KITTITAS COUNTY COMMUNITY DEVELOPMENT SERVICES

January 24, 2012

RE: Godzilla Short Plat (SP-11-00014)

The Kittitas County Community Development Services Department has determined that the Godzilla Short Plat (SP-11-00014) is a complete application and hereby grants *conditional preliminary approval* subject to the following conditions:

SHEET 1 OF 3

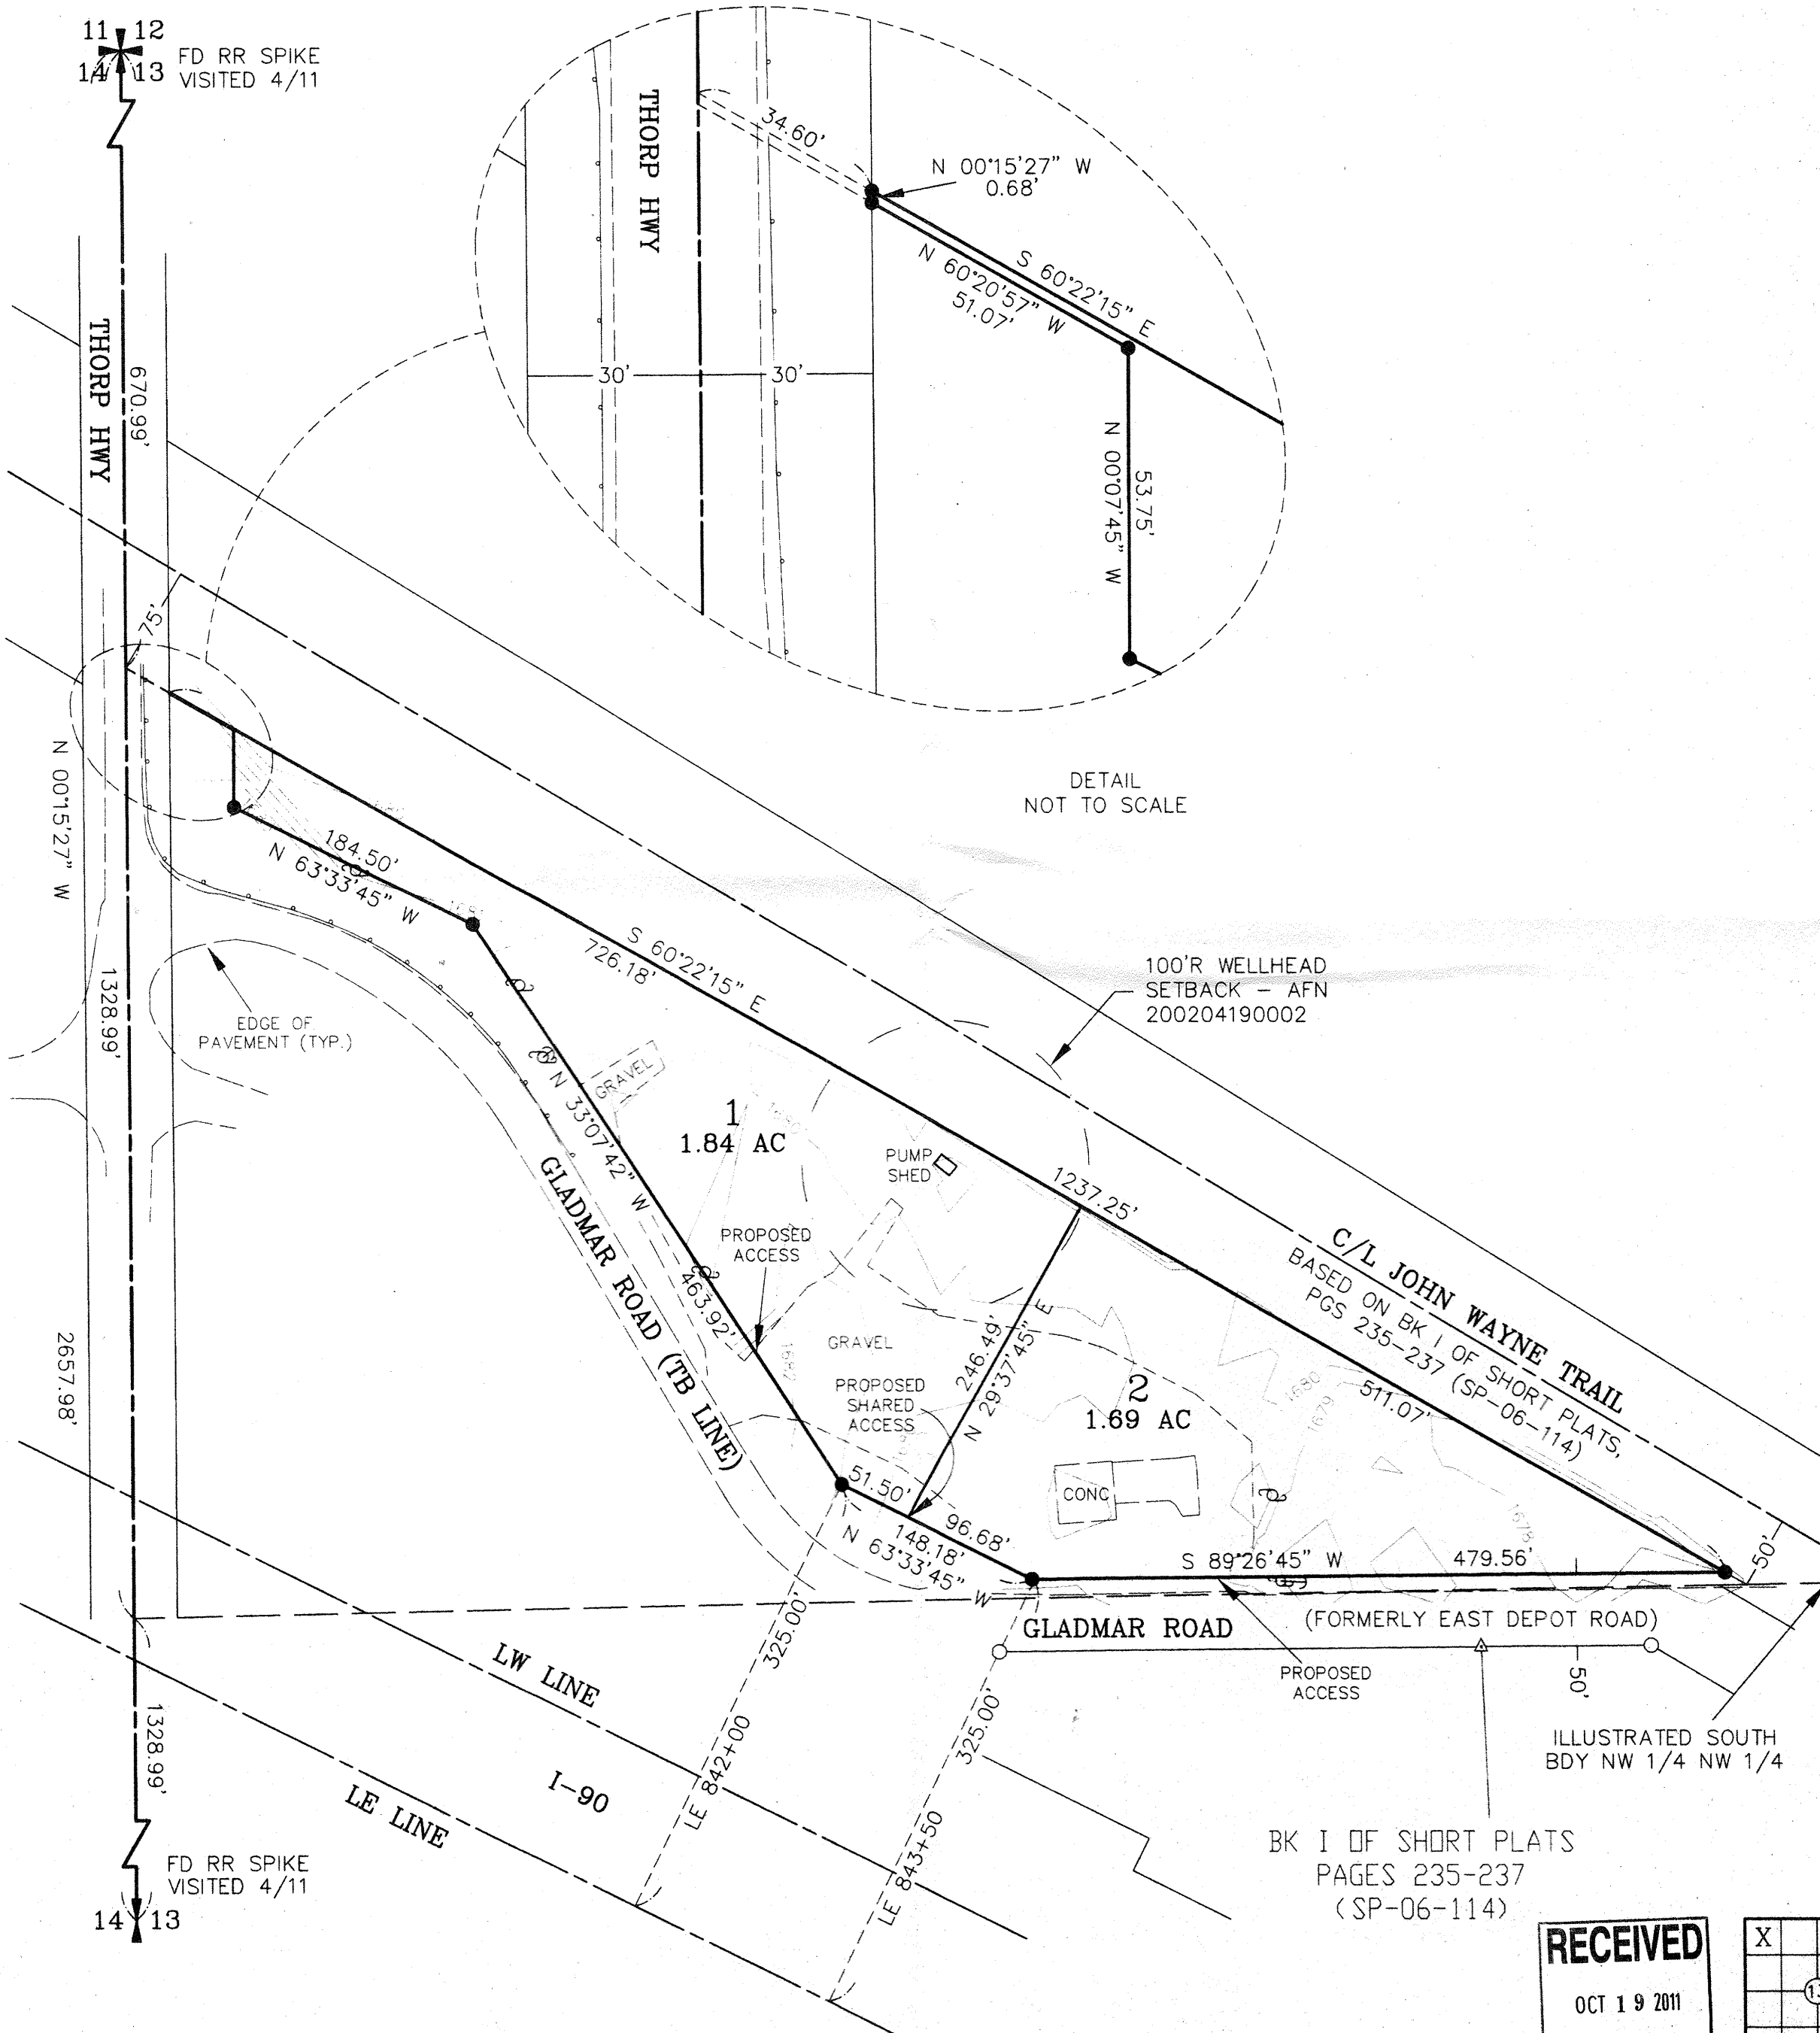
1. Both sheets of the final mylars shall reflect short plat number SP-11-00014 and an accurate legal description shall be shown on the face of the final plat.

4. The following plat notes shall be recorded on the final mylar drawings:
 - All development must comply with International Fire Code.
 - The approval of this division of land includes no guarantee that there is a legal right to withdraw groundwater within the land division. The approval of this division of land provides no guarantee that use of water under the ground water exemption (RCW 90.44.050) for this plat or any portion thereof will not be subject to curtailment by the Department of Ecology or a court of law.

6. A statement regarding the contemplated sewage disposal, water supply, and drainage improvements for the proposed subdivision shall be reflected on the final mylars.

7. Individual wells are required to have a 50 foot setback from neighboring property lines (KCC 17A.08.025). Please see the comments from Kittitas County Public Health Department for further information and requirements.

11. The addresses shall be clearly visible from both directions at the County Road for all properties.
12. The Fire Department access road shall be capable of supporting 75,000 lbs in all weather, be 20' wide, provide 13'6" vertical clearance and provide for adequate turn-around for fire department apparatus.
